Recommendation Report for Planning Permission for Works or Extension to a Dwelling

REF NO: BN/19/21/HH

LOCATION: 43 Elm Grove
Barnham
PO22 0HL

PROPOSAL: Two storey rear extension.

DRAWING NO.
04 REV A

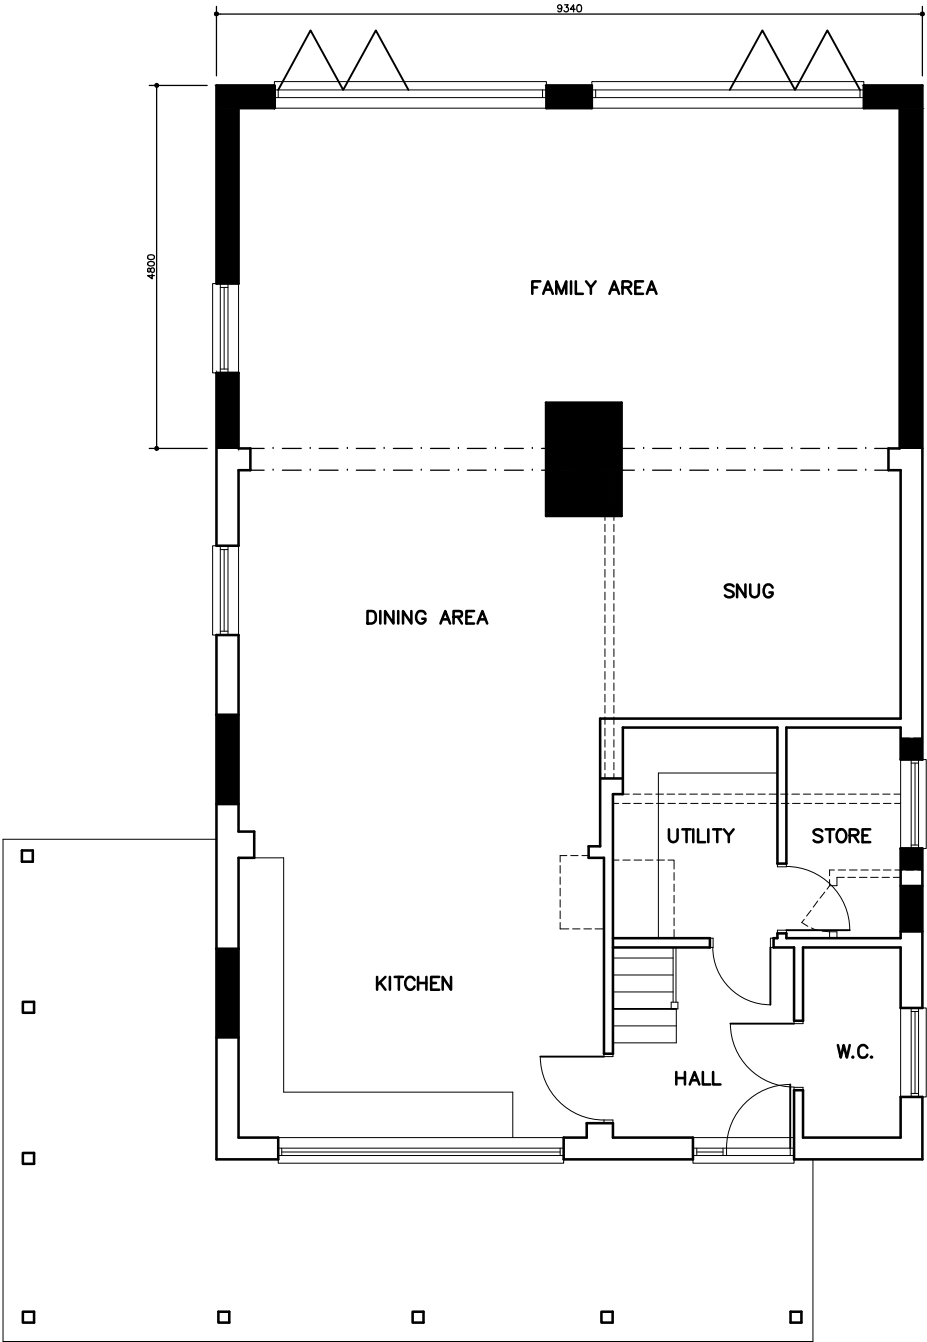
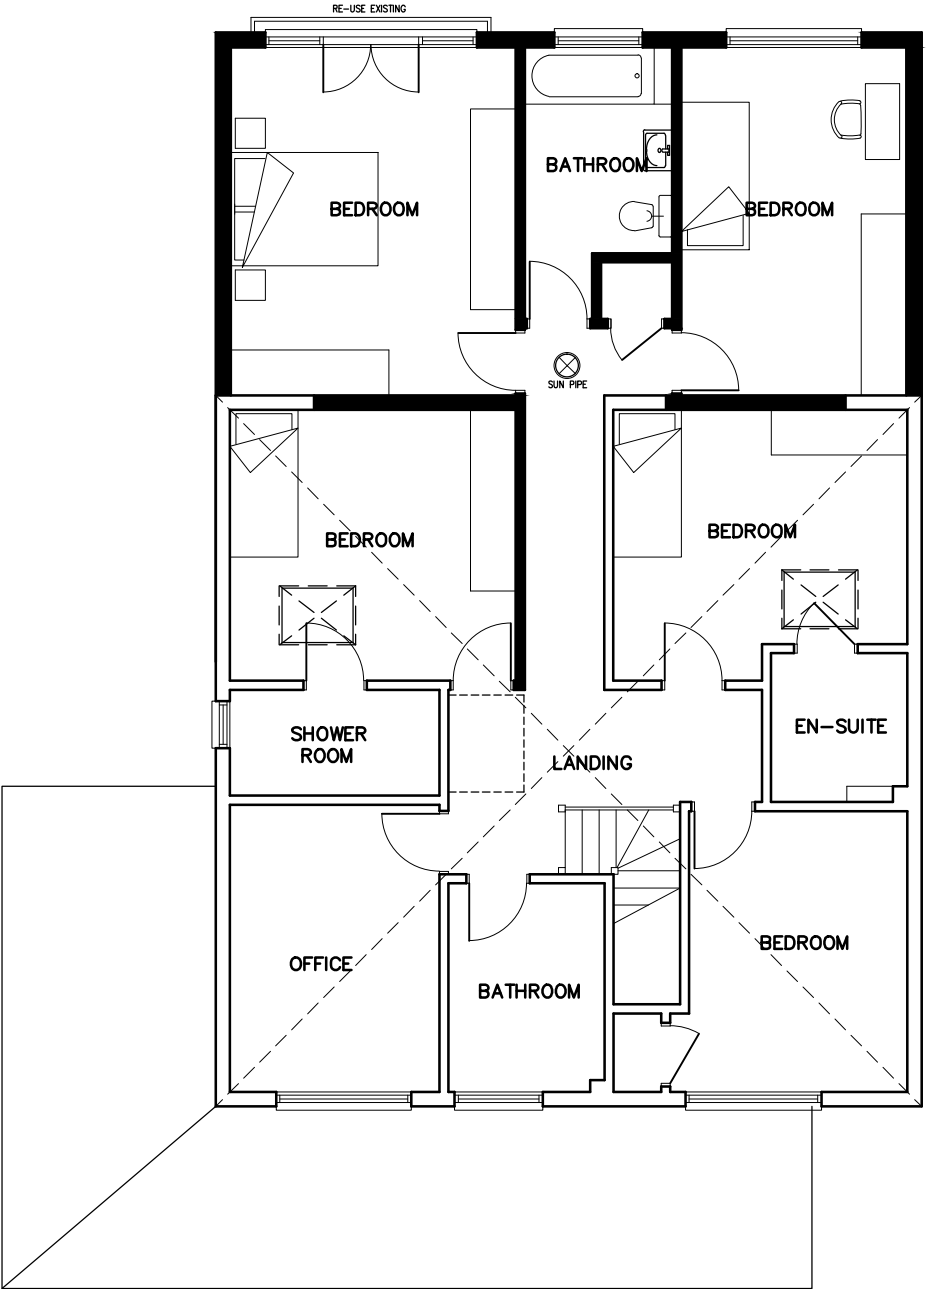
The extension will have a depth of 4.8m and extend along the full rear elevation. Whilst large at two storey, it retains 2.75m and 4m to the neighbouring boundaries and as a result of the siting of the properties and extension, it is not considered to appear overbearing or overshadowing upon amenity.

FOR MR S. DOWNES		
SITE 43 ELM GROVE, BARNHAM, WEST SUSSEX. PO22 0HL		
TITLE PROPOSED ELEVATIONS		
SCALE 1:100	DRAWN AH 02/21	DRAWING NO. 05 REV A

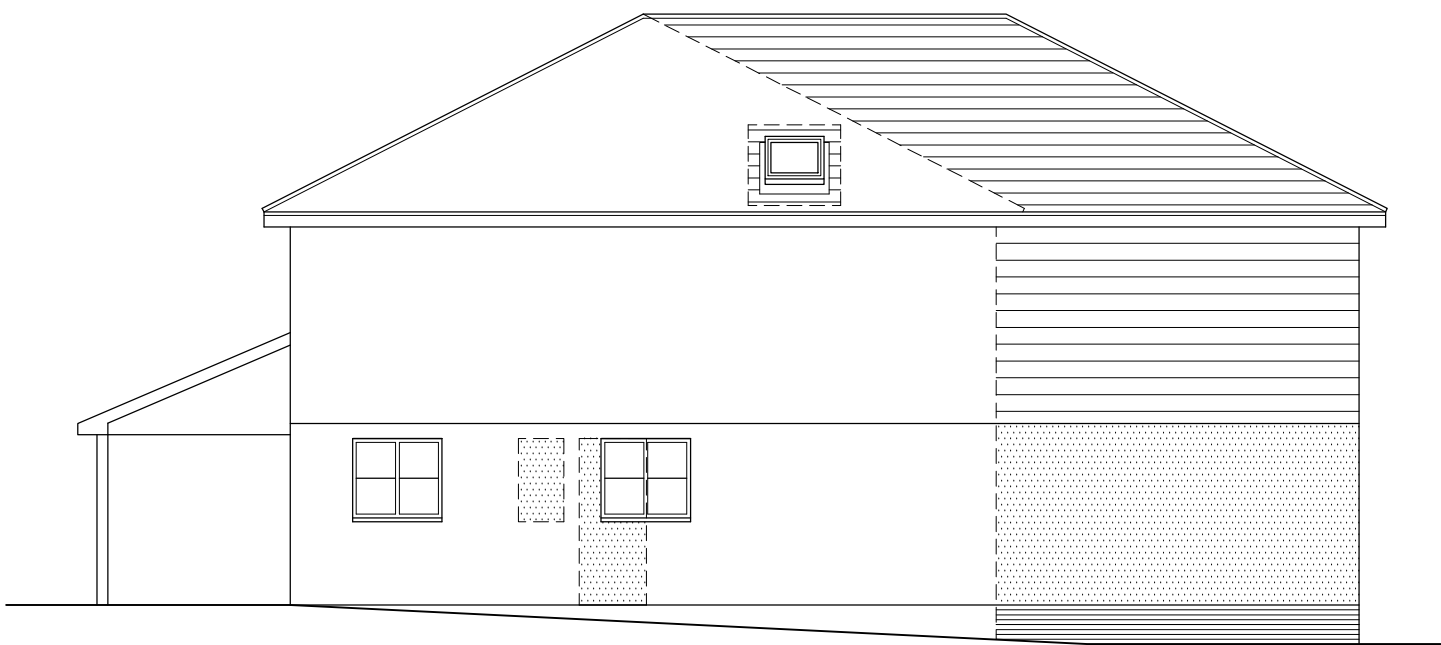
The development will form a two storey extension with a depth of 4.8m. This will run along the full rear elevation. It is considered to appear well integrated with the host dwelling, extending from the ridge line forming a hipped roof to match that of the main dwelling.

Materials will also match the host dwelling which consists of cladding to the first floor. This seeks to ensure that the addition appears sympathetic in appearance.

There will be 2 windows and a juliet balcony to the first floor which replace existing. Whilst they are situated further into the rear garden, than compared to the existing rear elevation, it is not considered to provide additional overlooking above that which is already achieved, with no views into direct neighbouring windows. Approximately 40m is retained to the rear boundary and with no neighbours to the rear boundary, again it is not deemed to result in adverse overlooking.
